# KITITAS COUNTY

## DEPARTMENT OF PUBLIC WORKS

### MEMORANDUM

**TO:** All Staff  
**FROM:** Public Works Plan Review Team  
**DATE:** March 30, 2026  
**SUBJECT:** BL-26-00002 Fowler Creek Trails

BOUNDARY LINE ADJUSTMENT BL-25-00002

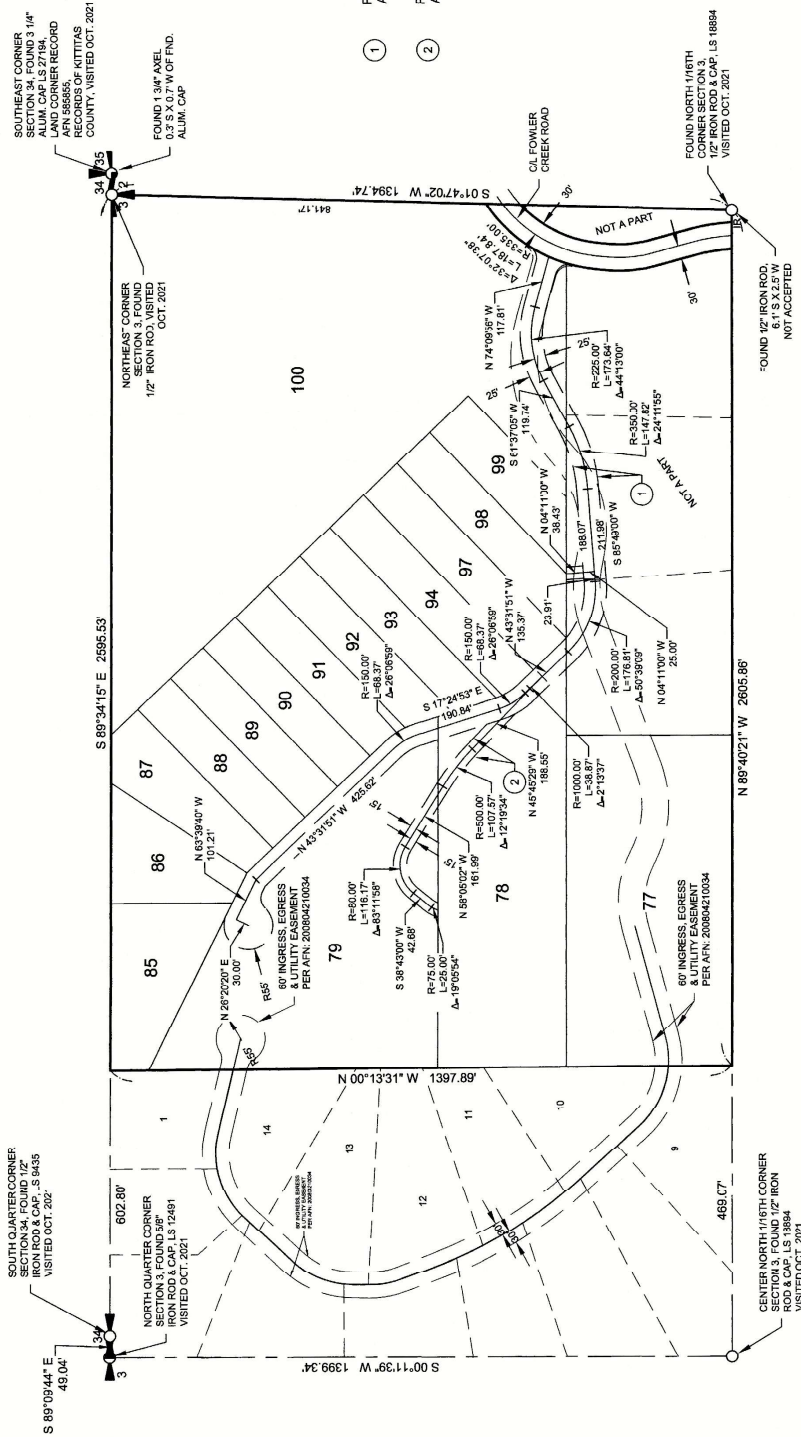
<b>ACCESS</b>	<ol style="list-style-type: none"> <li>1. Provide access easement to all lots, appears as the properties to the west on proposed site plan will no longer have an easement for access.</li> <li>2. An approved access permit shall be required from the Kittitas County Department of Public Works prior to creating any new driveway access or altering an existing access.</li> <li>3. Per KCC 12.04.04.050 Road Certification is required for road serving 4 or more parcels prior to final approval.</li> <li>4. Per KCC 12.04.01.030 Roads serving five or more lots shall be named according to the Kittitas County Private Road Naming &amp; Signing Standards prior to final approval.</li> <li>5. Maintenance of driveway approaches shall be the responsibility of the owner whose property they serve. The County will not maintain accesses.</li> <li>6. Any further subdivision or lots to be served by proposed access may result in further access requirements. See Kittitas County Road Standards.</li> </ol> <p>In addition to the above-mentioned conditions, all applicable Kittitas County Road Standards apply to this proposal. Access is not guaranteed to any existing or created parcel on this application. (RC)</p>
